**From:** Brenda Larsen  
**Sent:** Wednesday, January 30, 2013 10:36 AM  
**To:** Jeff Watson  
**Subject:** RE: BL-12-00030 Evergreen Valley

Re: Evergreen Valley (BL-12-00030)

After conducting a review of the above named project, I have the following comments:

Proposed Layout

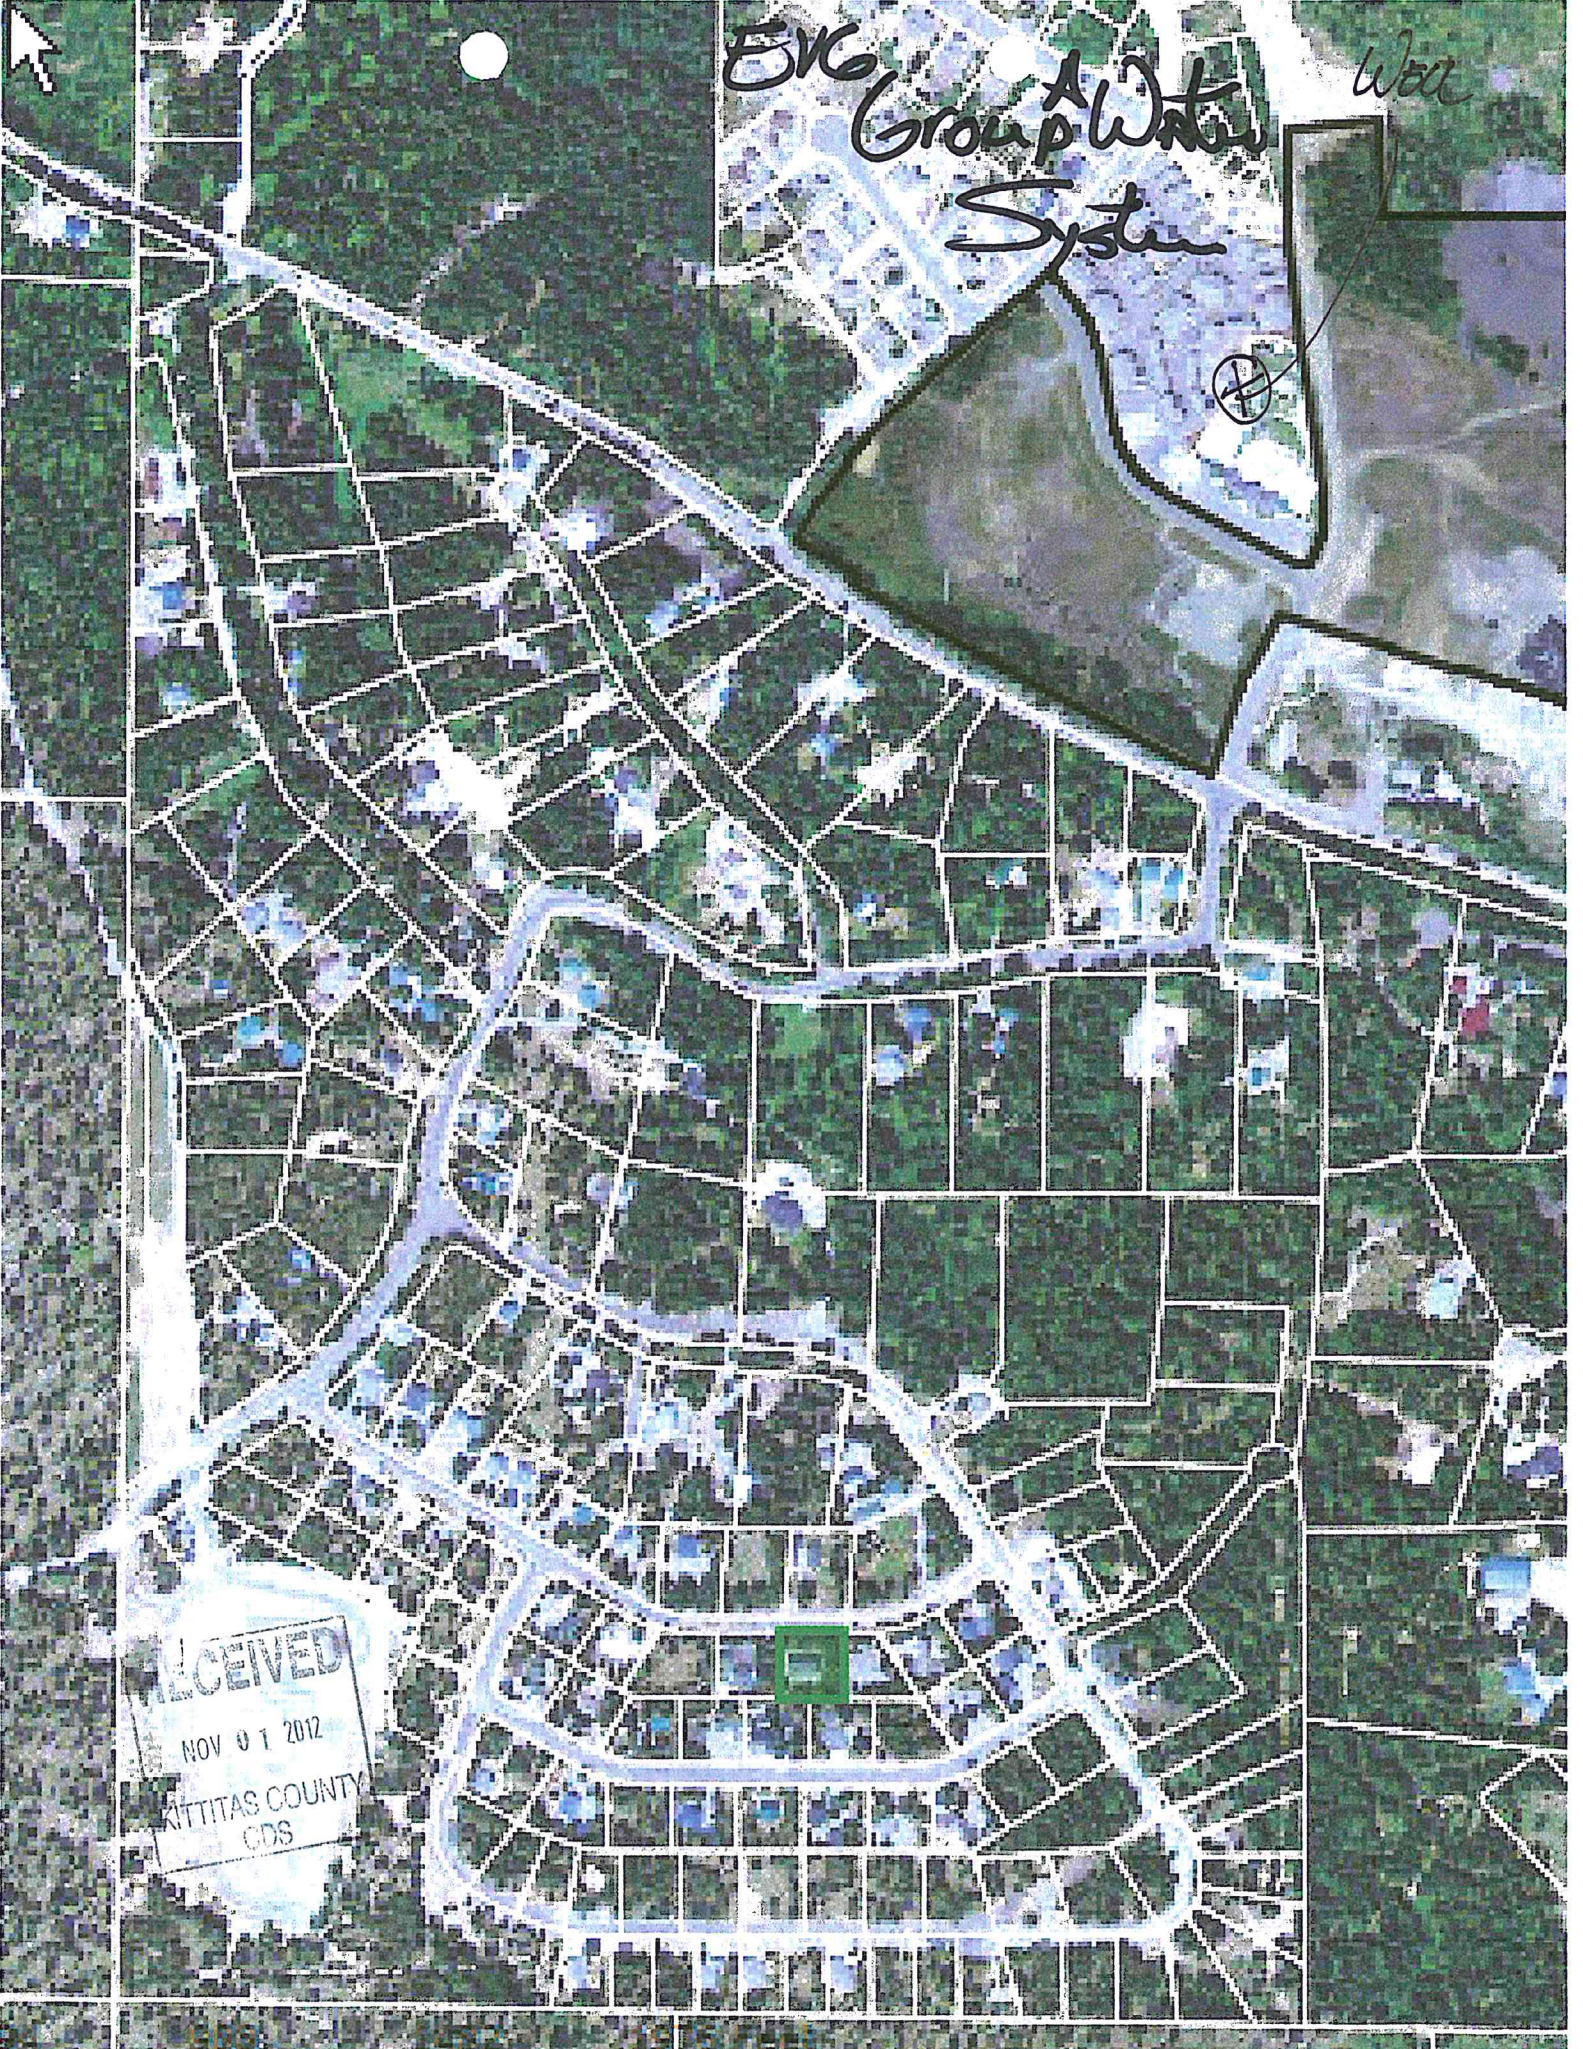
- Any new roads that are created are to comply with Kittitas County Road Standards and the International Fire Code.
- Ensure that boundary line adjustments do not infringe upon existing structures, to include propane tanks, etc.
- All future development must comply with the International Fire Code.
